Re: Permit #2212-162
Rader SFR Addition and Remodel
7310 86th Ave SE
Intake Comment Response Letter

Regarding the combined intake comments dated 1/4/23 for the remodel/addition permit application listed above, we would like to provide the following corrections and locations on the drawings where they can be found (responses are bulleted and italicized below summarized comment):

EXTERIOR ELEVATIONS

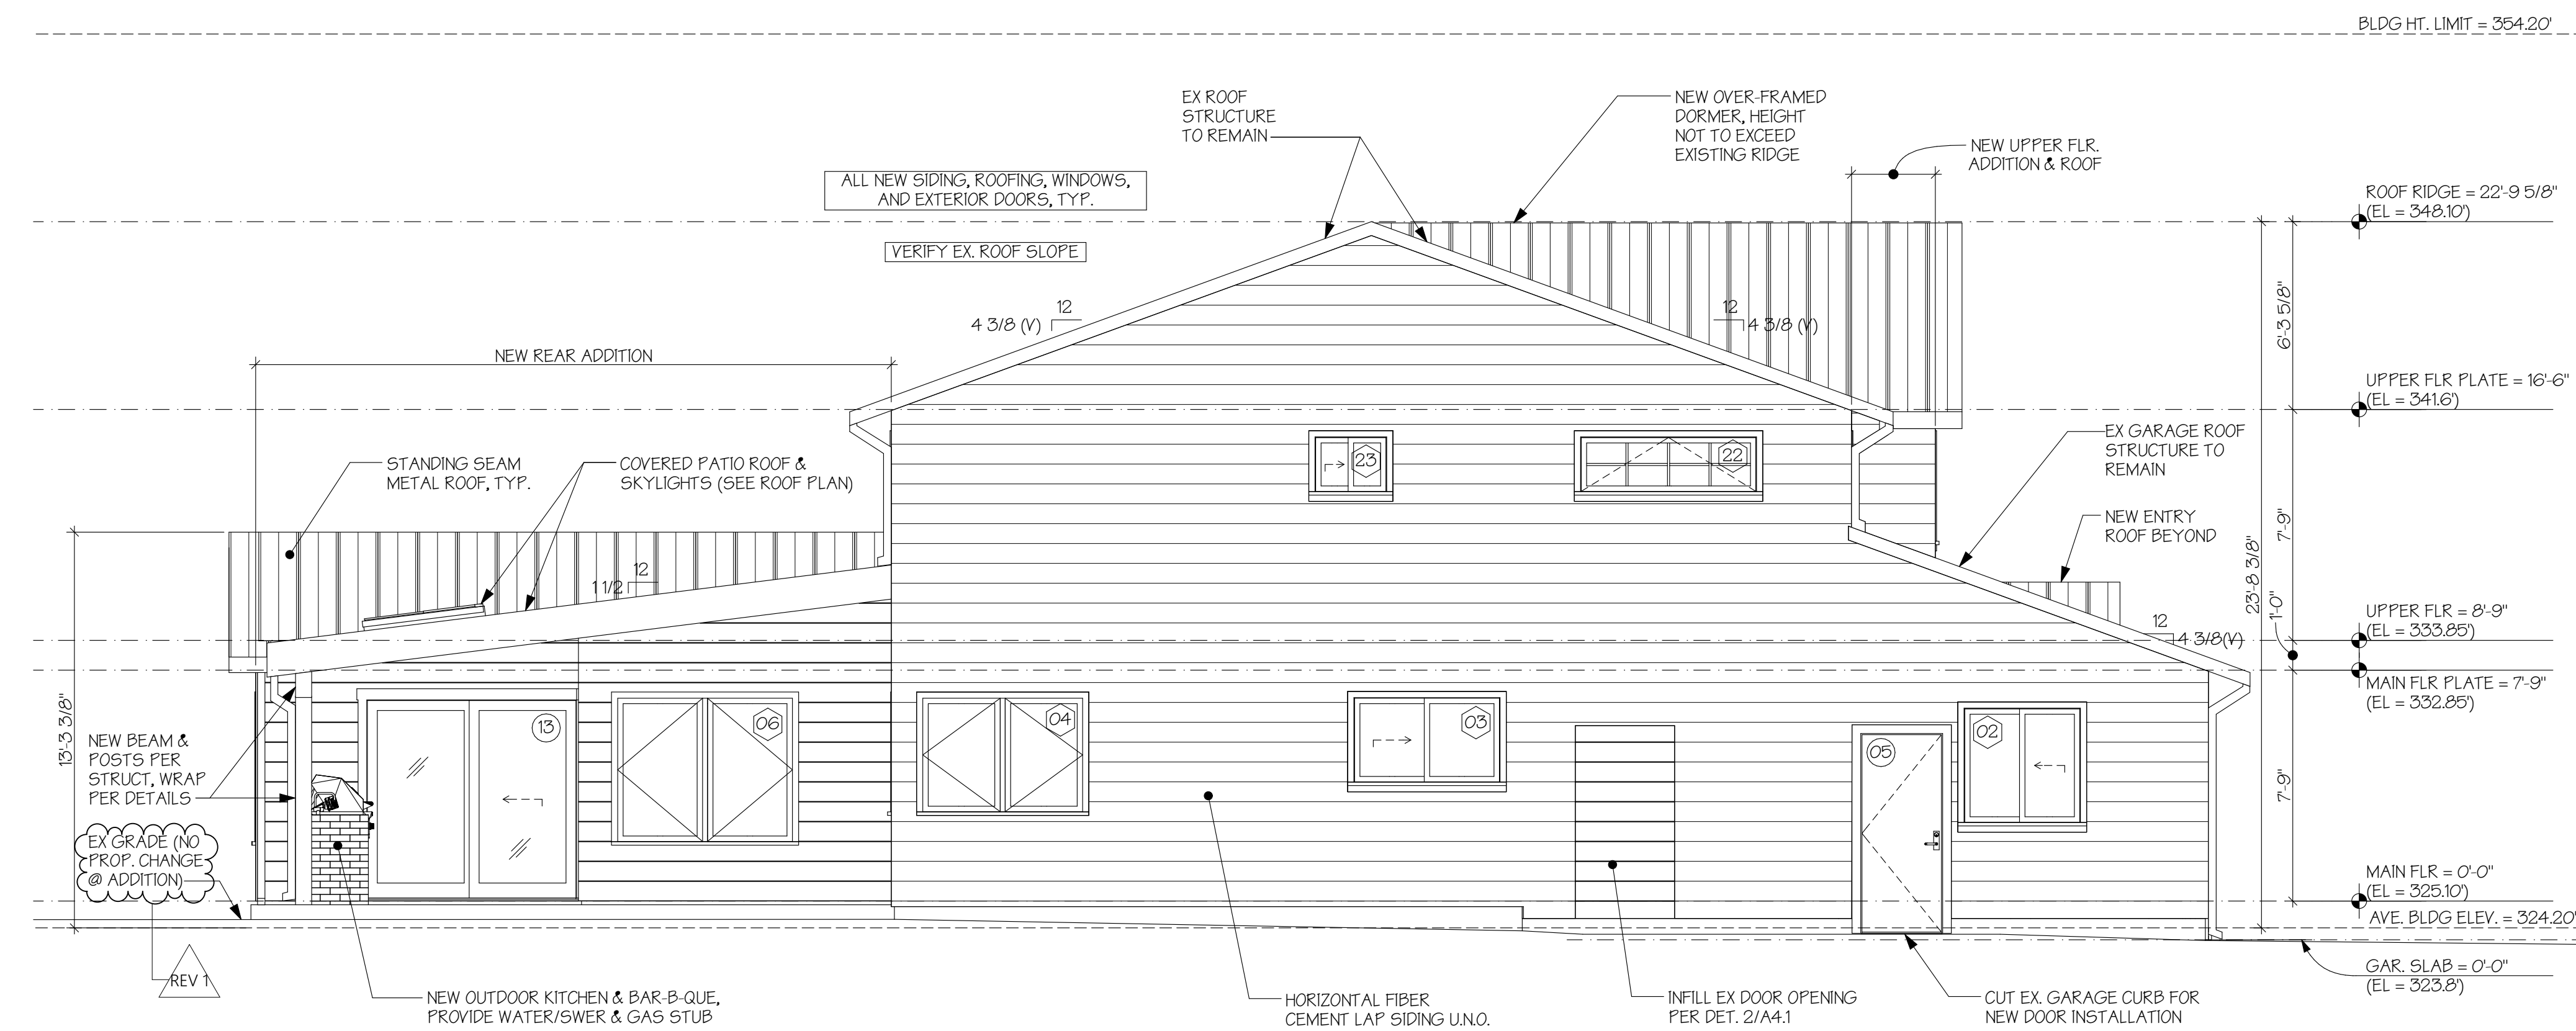
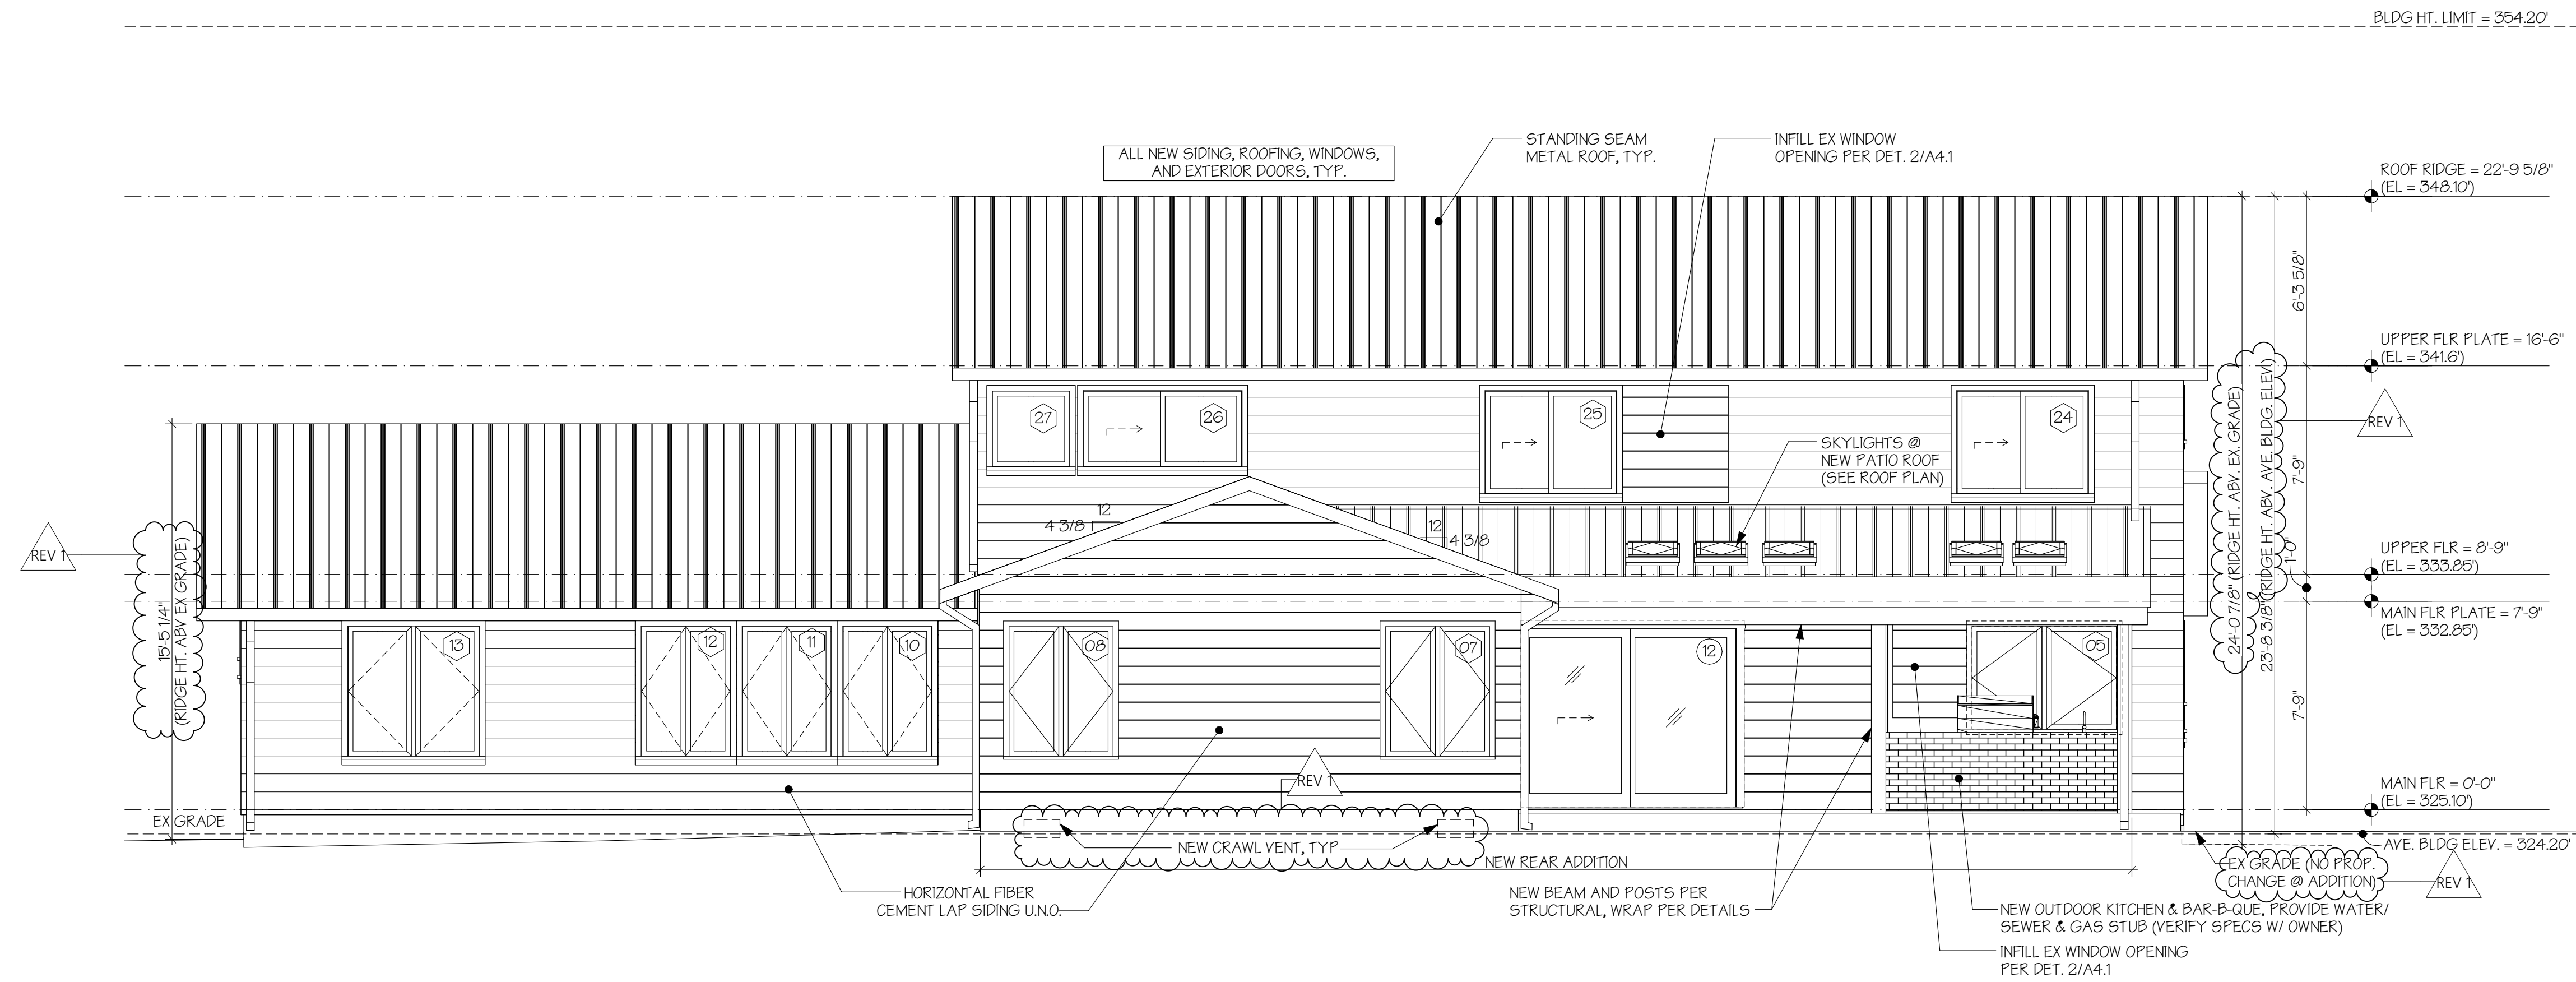
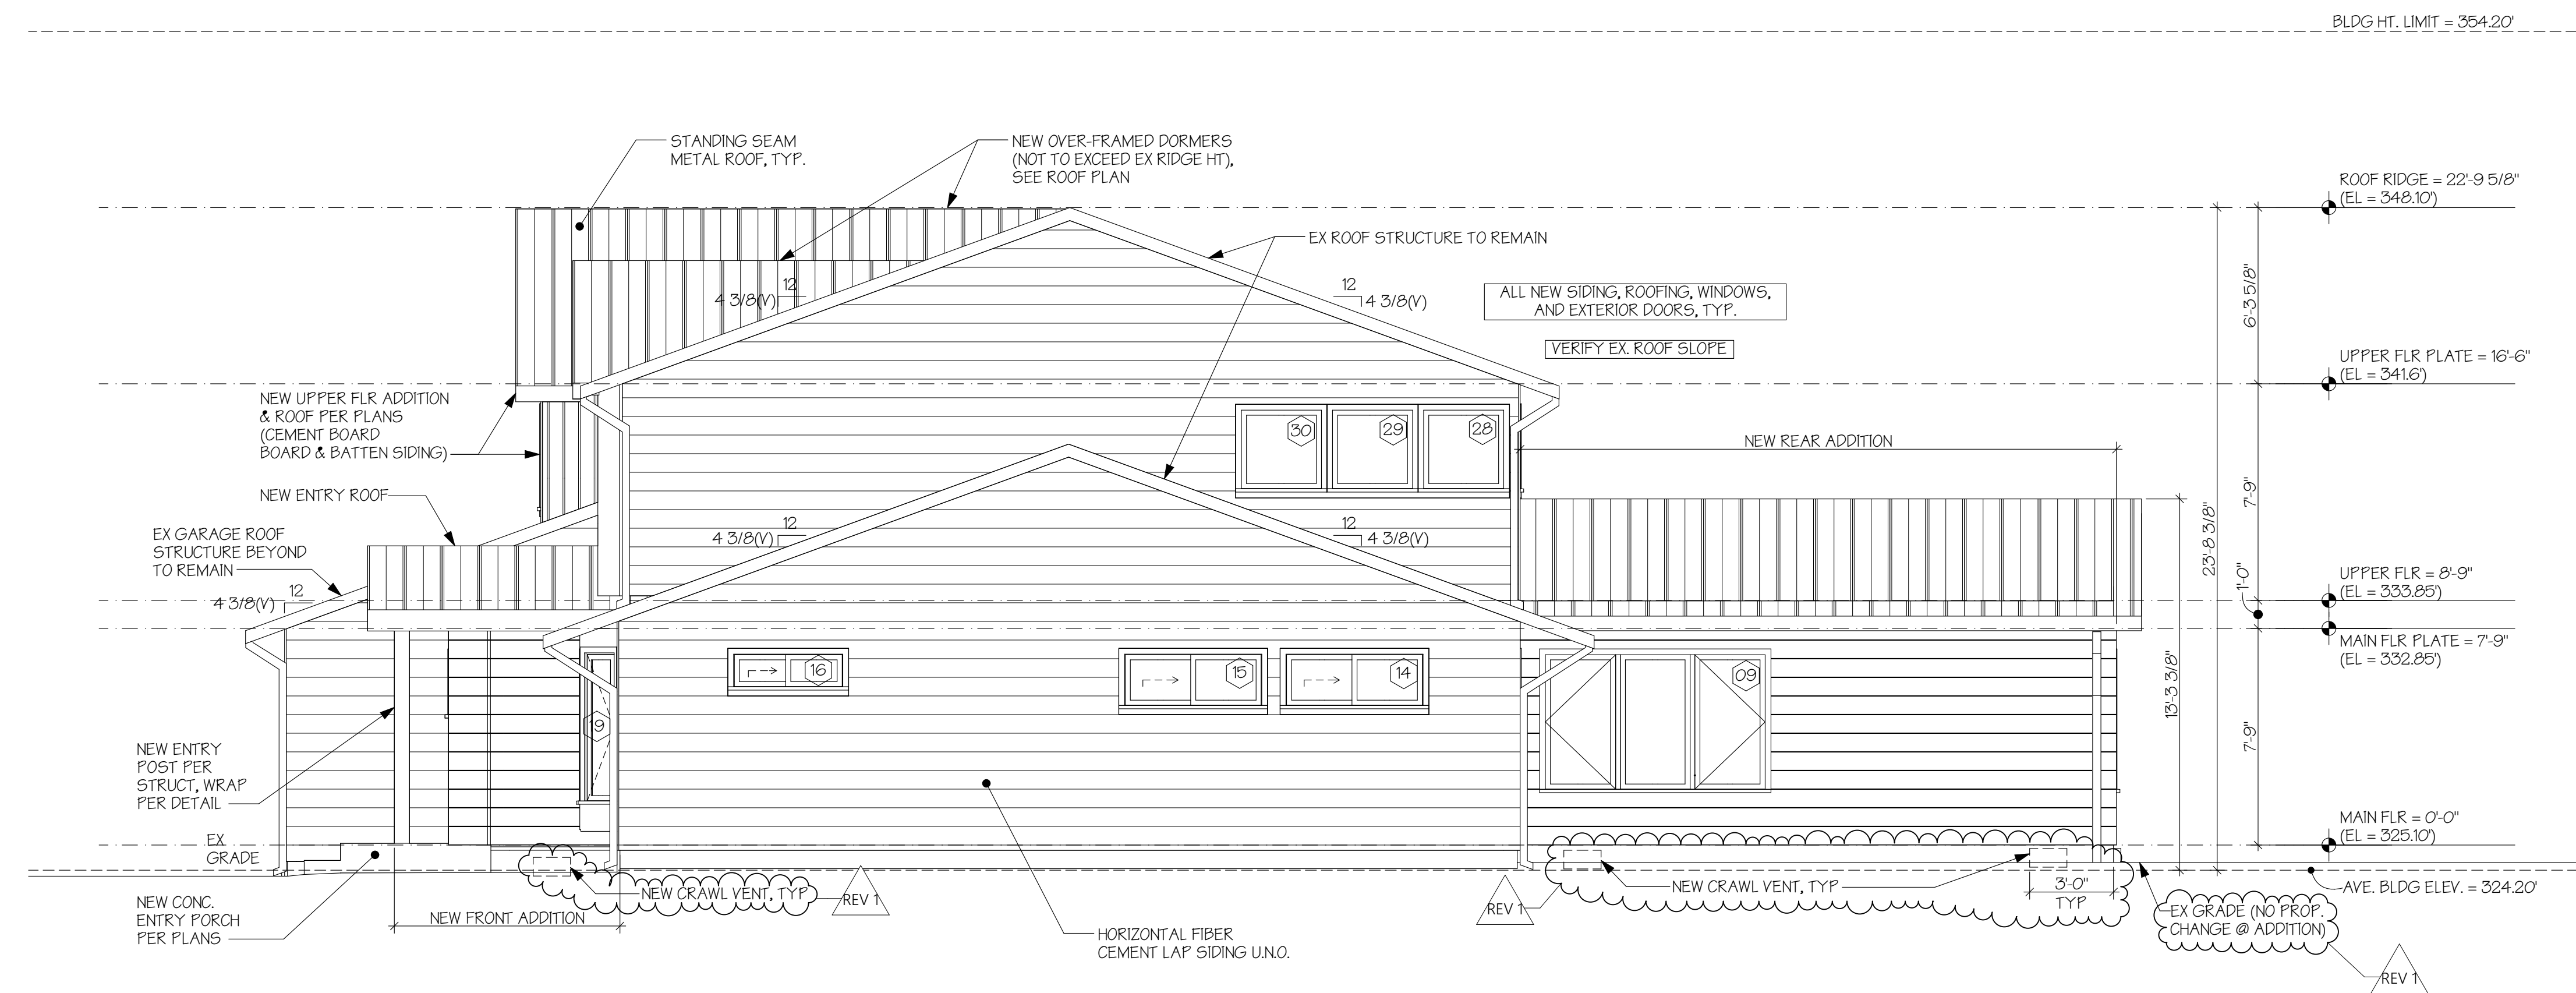
- v. *Development plan set taking into account all recommendations from geotechnical evaluation*
3. Correct side yard setbacks in compliance with MICC 19.02.020(C)(1)(c)(iii).

- *For clarity, additional roof-height dimensions above finished grade have been added to West (front) and East building elevations, see sheets A2.0 and A2.1. We believe side yards have been identified correctly on the site plan (sheet 02). At the minimum side setback of the property (south side), the existing gabled roof end adjacent to the side yard does not exceed 18'-0" above finished grade, so the minimum side yard dimension would be 5'-0" per sec. (C)(1)(c)(ii), or 33% of the aggregate total width, which for this lot is 15'-0" (90'-0" or less lot width). The remaining side yard dimension on the north would be 10'-0" (which allows a ridge ht. of 25'-0" or more; although the max ridge height here does not exceed 25'-0"). Neither the existing nor proposed building footprint encroaches into either side yard.*
